**WEST SUSSEX COUNTY COUNCIL
STRATEGIC PLANNING CONSULTATION**

SUBJECT: EG/1/14 - Proposed new timber clad caravan/ camper/ trailer store with pitched gabled roof and driveway widening.

Wanley Lodge, Wandleys Lane, Eastergate, West Sussex, PO20 3SE

RECOMMENDATION:

Block Plan Scale 1:200

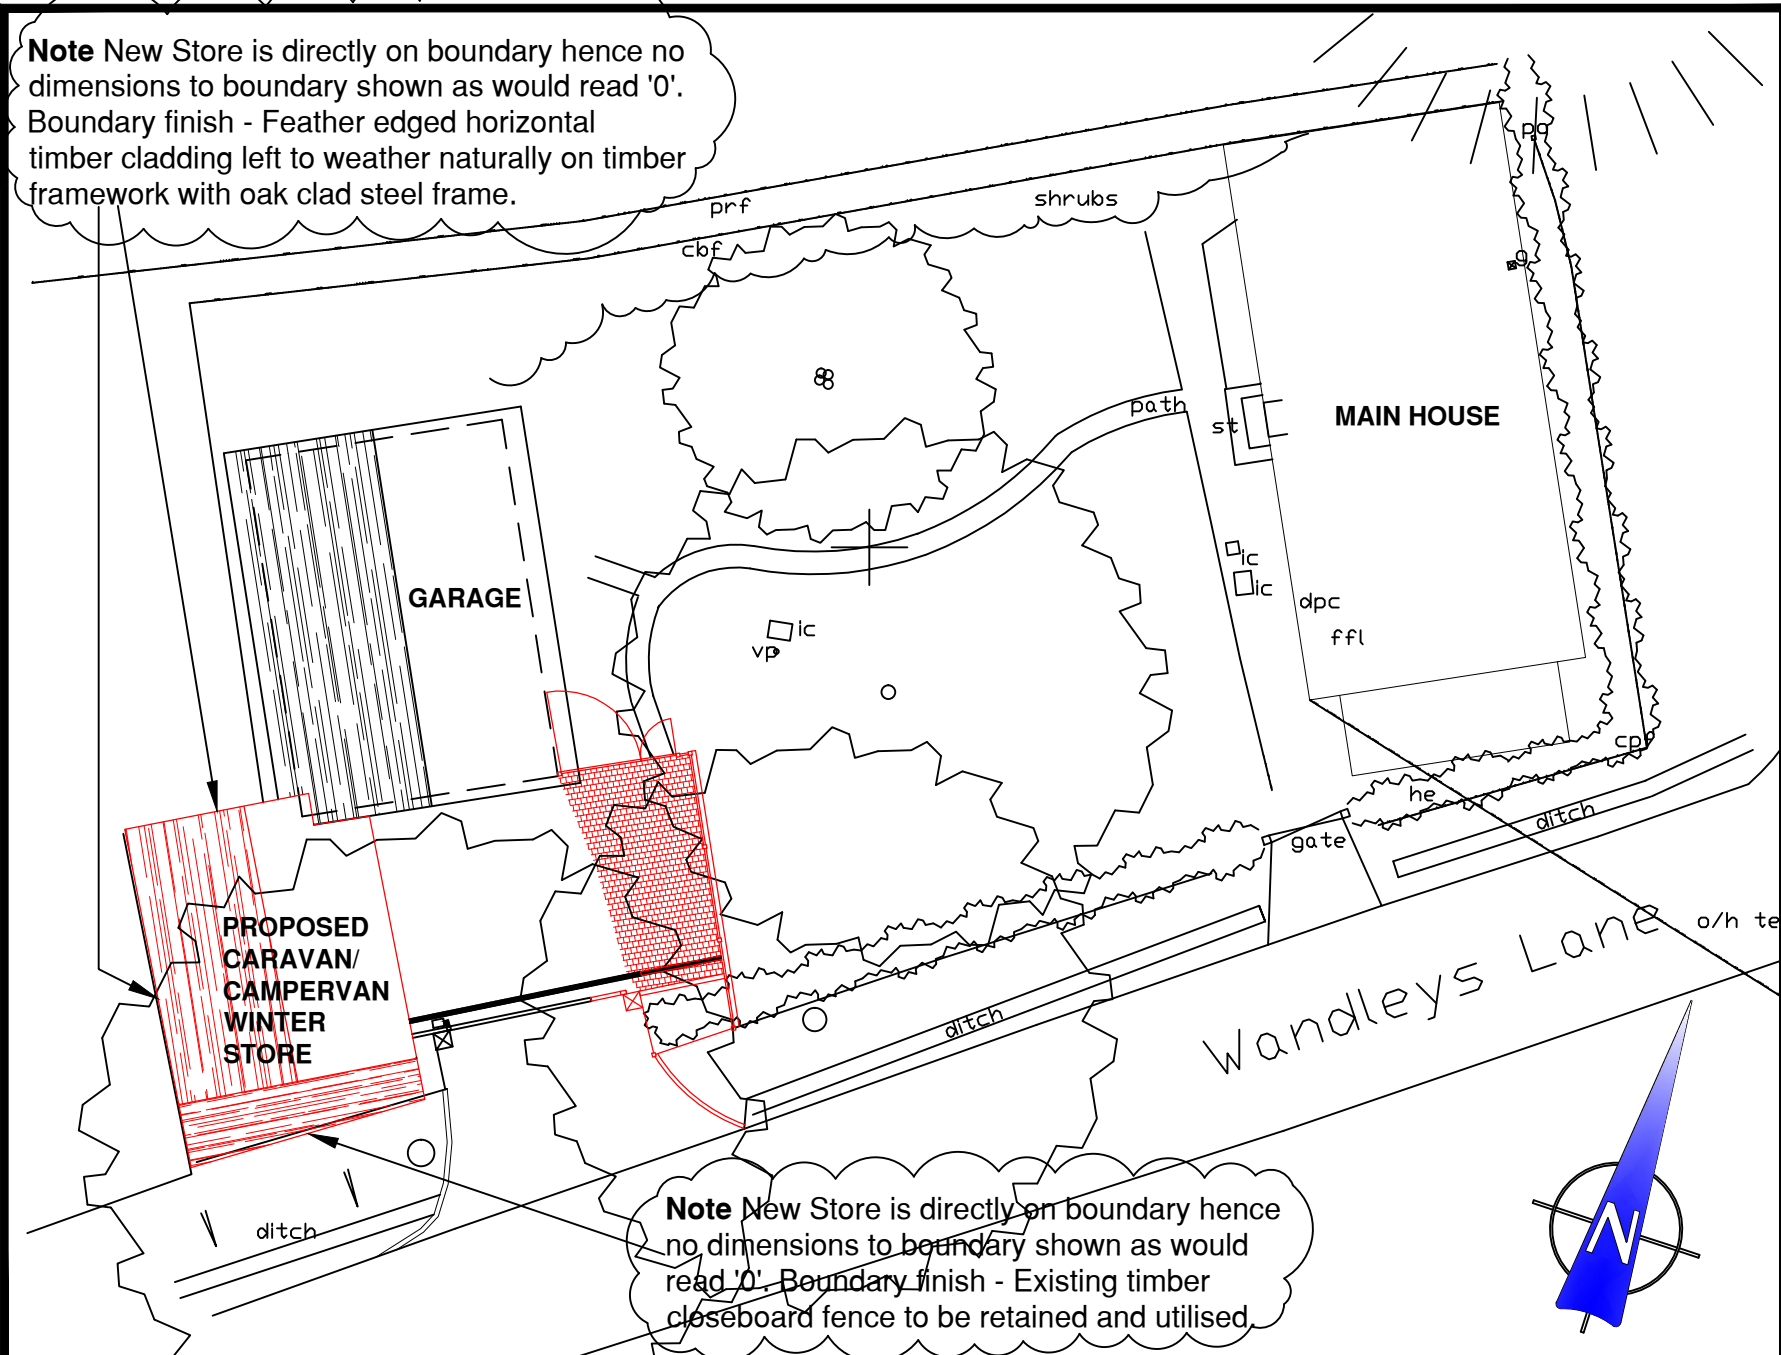
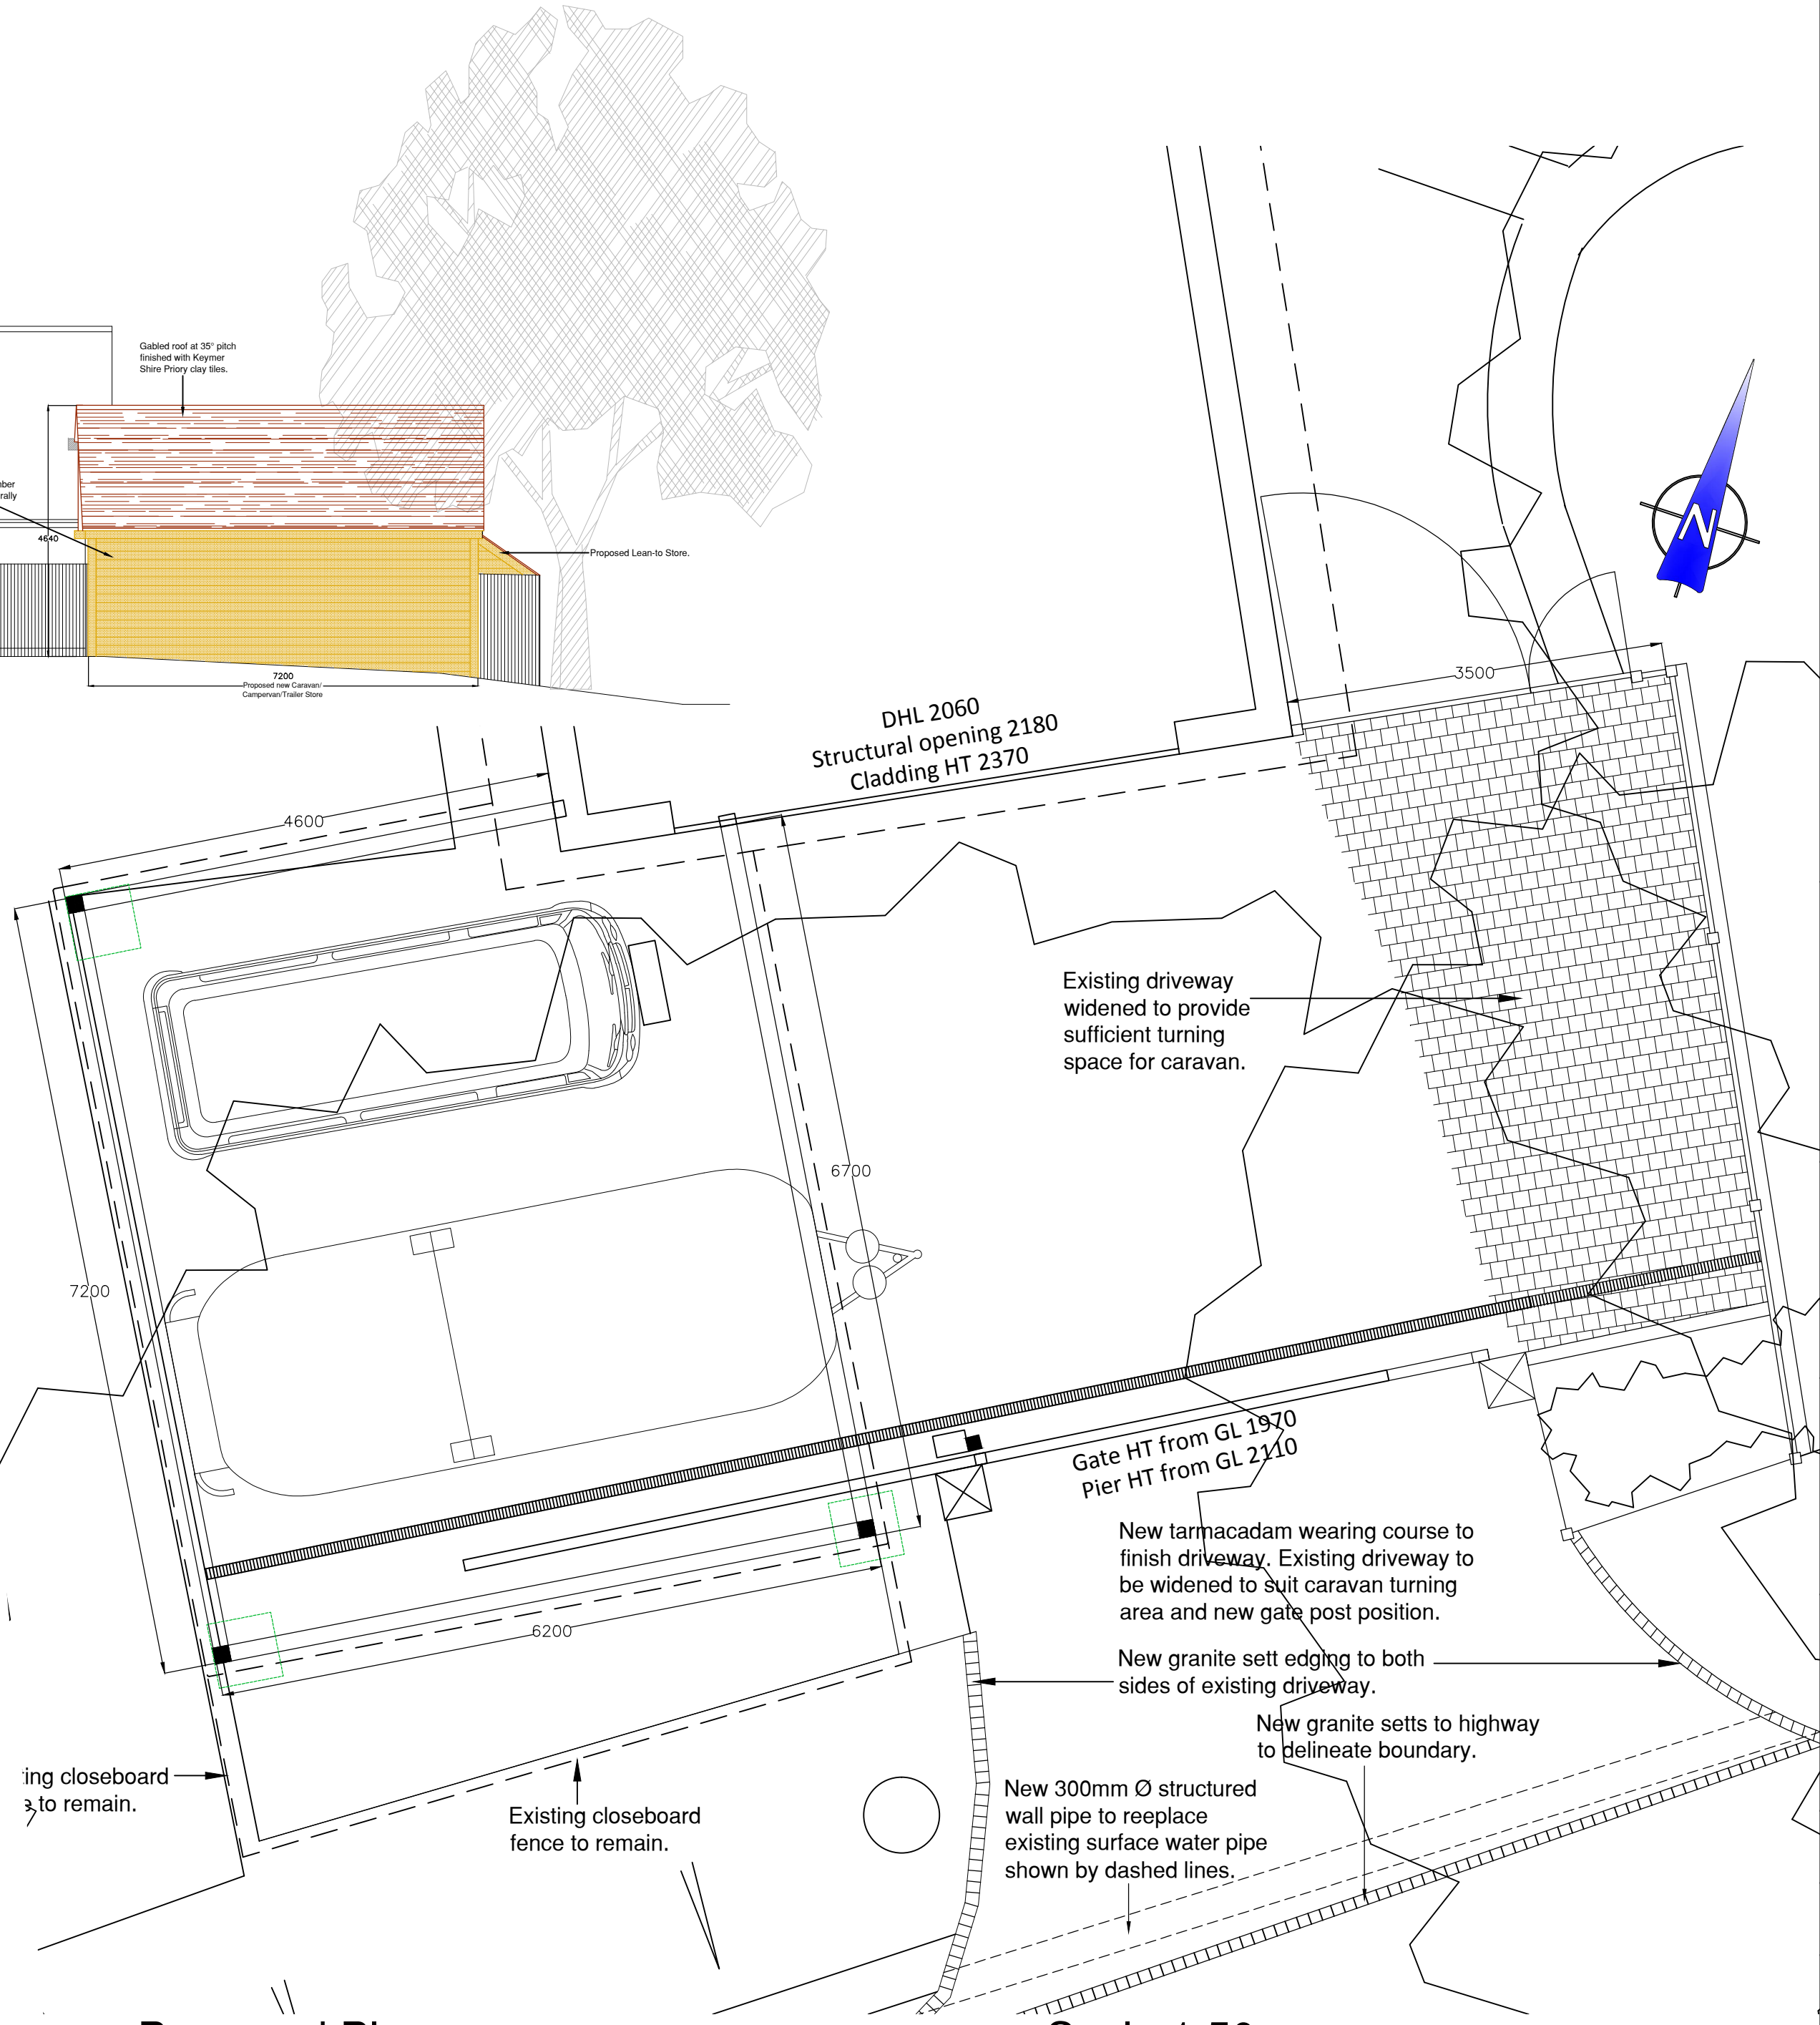
The application seeks approval for the construction of a new winter store for a campervan/caravan with associated widening of the existing access to cater for this. From inspection of the plans and information provided, it is proposed to widen the existing access by 900mm to the east to allow for easier manoeuvres for larger vehicles. No concerns to this would be raised from a highway safety perspective.
